CITY OF ALBUQUERQUE

June 18, 2024

Sites: D&B U Sell It at 401 Unser Blvd. and 8530 Bluewater Rd. NW (K10E068)

Re: Drainage Ordinance (14-5-2-11) Violations for Erosion and Sediment Control

RUNOFF AND PONDING CALCULATIONS
TRACTS 5/BLK 2 AND TRACT B
CLIFFORD WEST BUSINESS PARK, UNIT 1

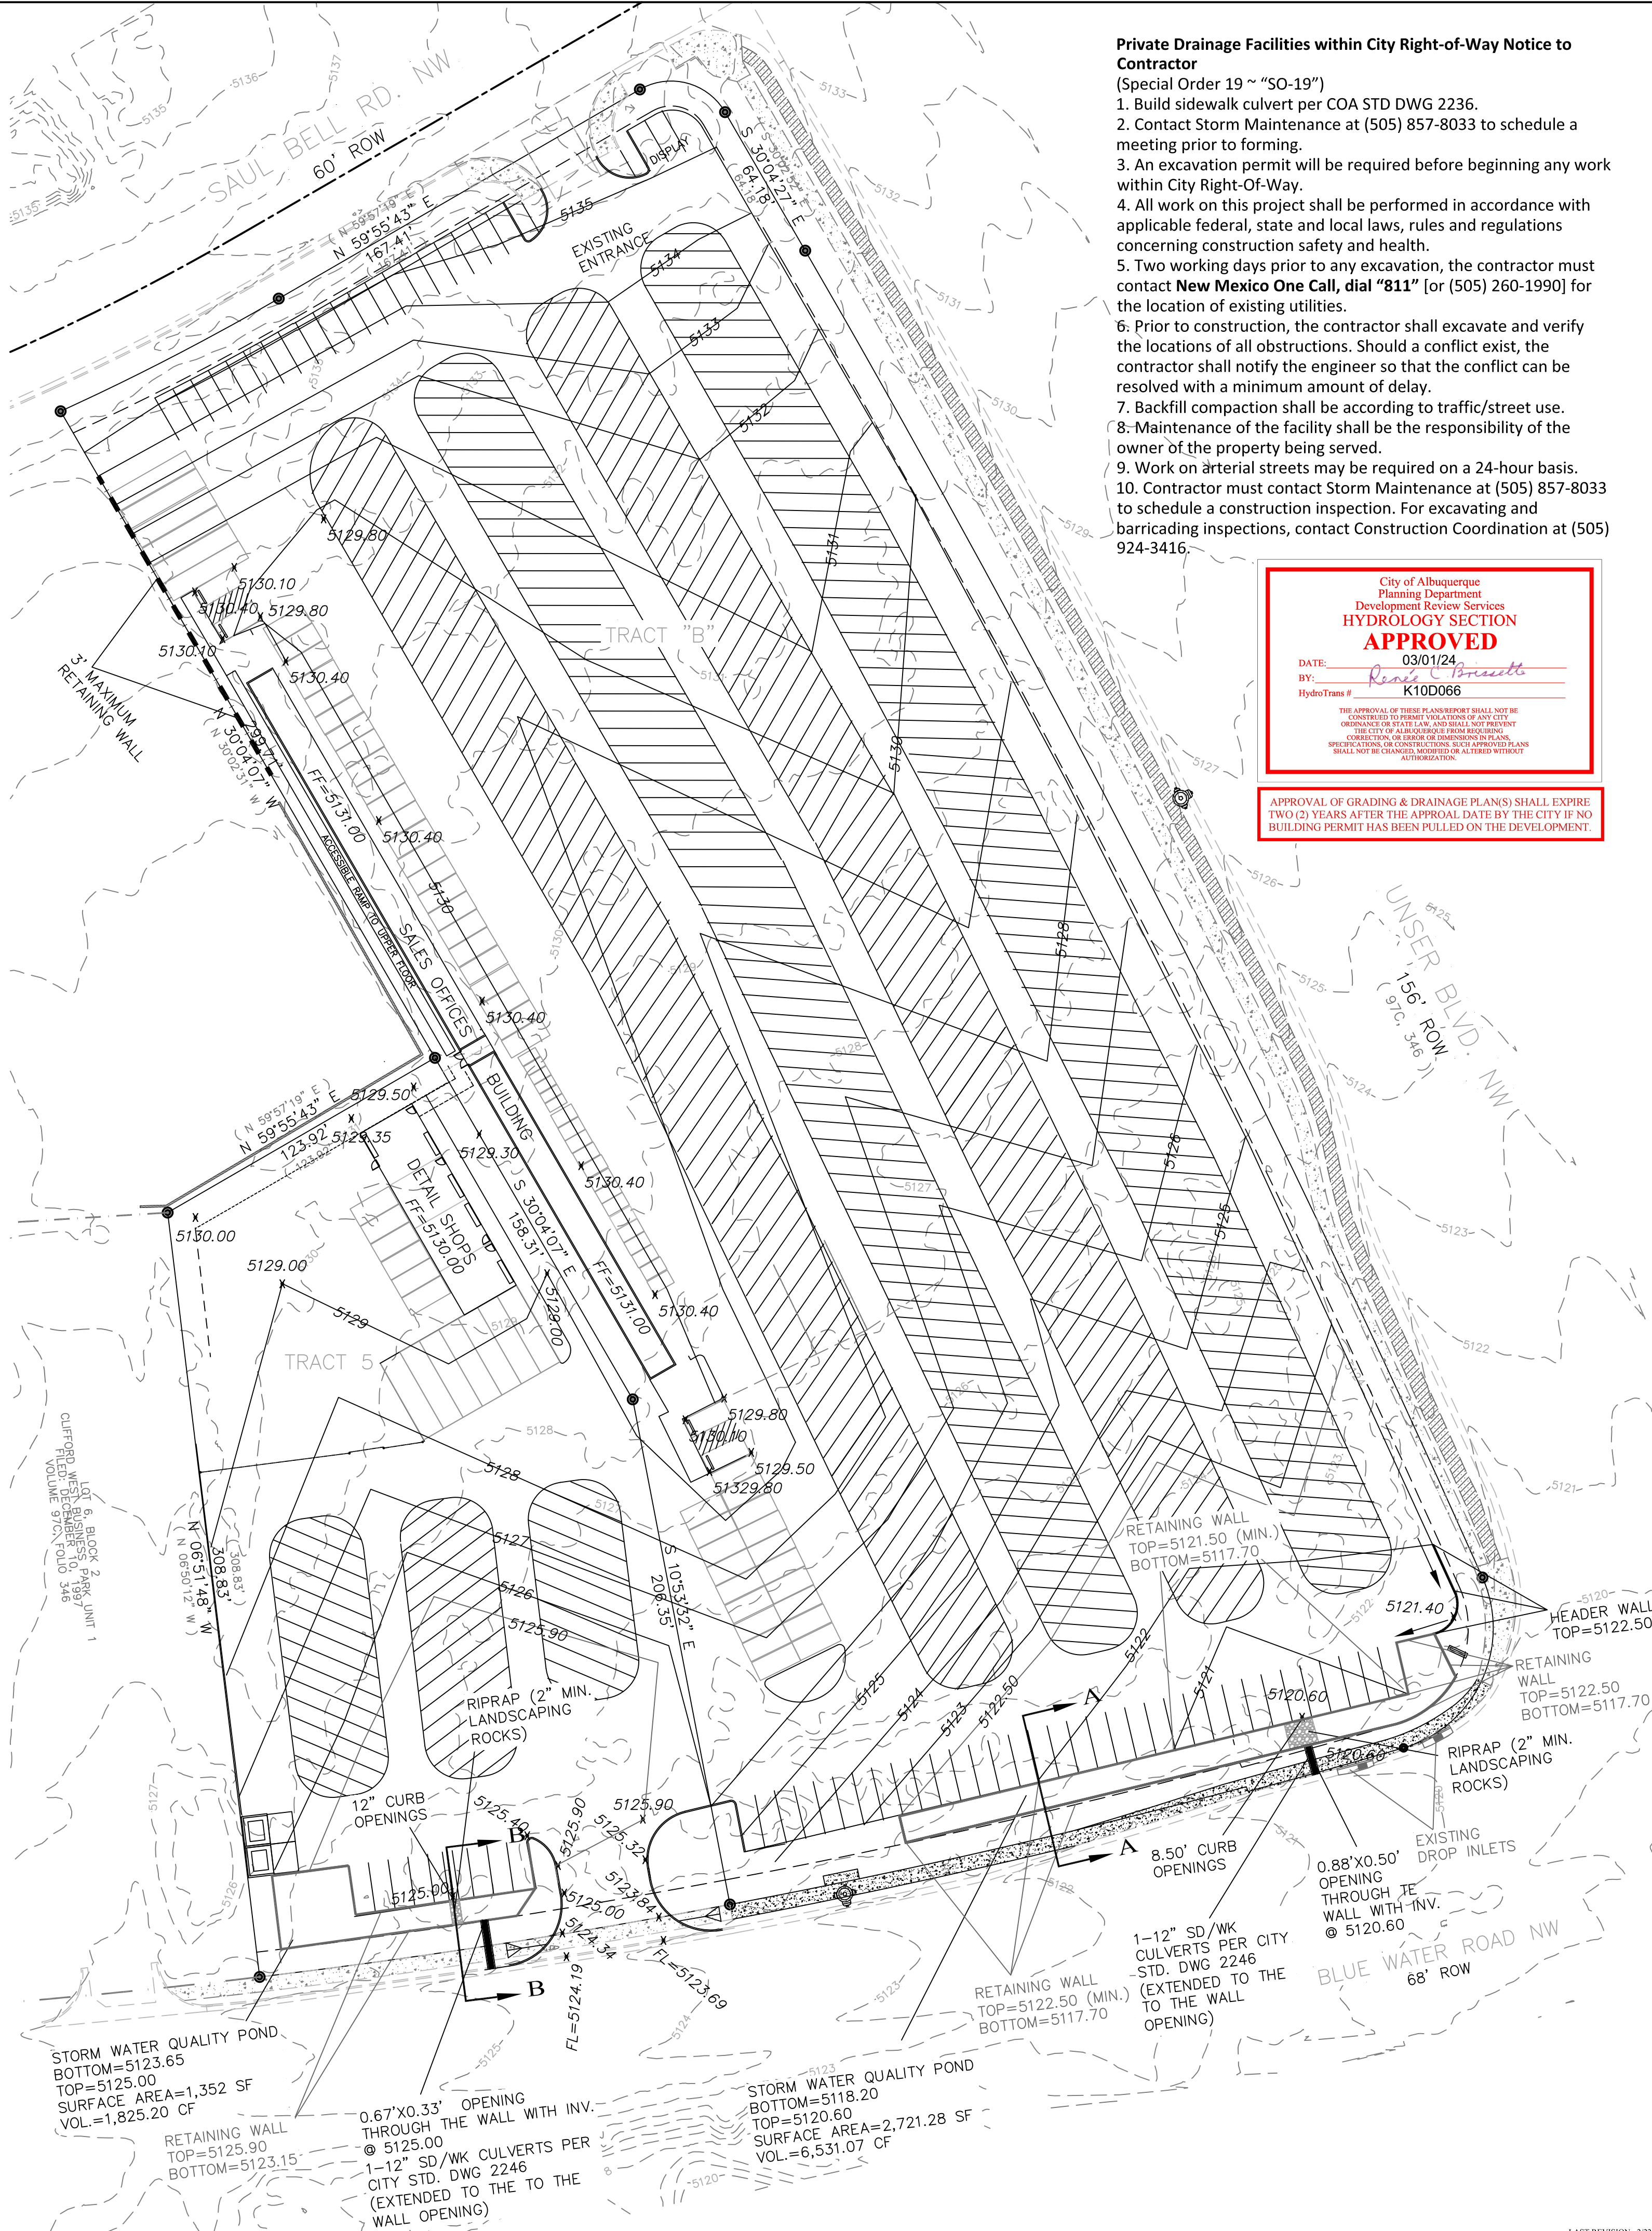
1. **BMPs**—The pond(s) volume looked too small and was located east of the concentrated flow path, which appears to exit the site west of the small pond in violation of CGP 2.1.2. The pond installation was incomplete in violation of CGP 2.1.3, with inadequate volume, concentrated flow path bypasses the pond, and the overflow wasn't stabilized. Sediment Trap design volume calculations and construction specifications were missing in violation of CGP 2.2.12 and the city's ESC Plan checklist.

1. **BMPs** - CGP Part 2.1.2 requires you to design and install all stormwater controls in accordance with good engineering practices, including applicable design specifications. You must finish the sediment basin design per CGP 2.2.12, including design calculations and construction specifications. The ESC Plan and pond design must be submitted to the City of Albuquerque for review and approval per Albuquerque's Erosion and Sediment Control (ESC) ordinance § 14-5-2-11. You must also complete the installation before the next city inspection per the city ordinance and the escalation process. You must also ensure all stormwater controls are maintained and remain in effective operating condition during permit coverage, per CGP Part 2.1.4. If at any time you find that a stormwater control needs routine Maintenance, you must immediately initiate the needed maintenance work and complete such work by the close of the next business day per CGP 2.1.4.b. When the problem requires a new or replacement control or significant repair, install the new or modified control and make it operational or complete the repair by no later than seven (7) calendar days from the time of discovery per CGP 5.2.1.
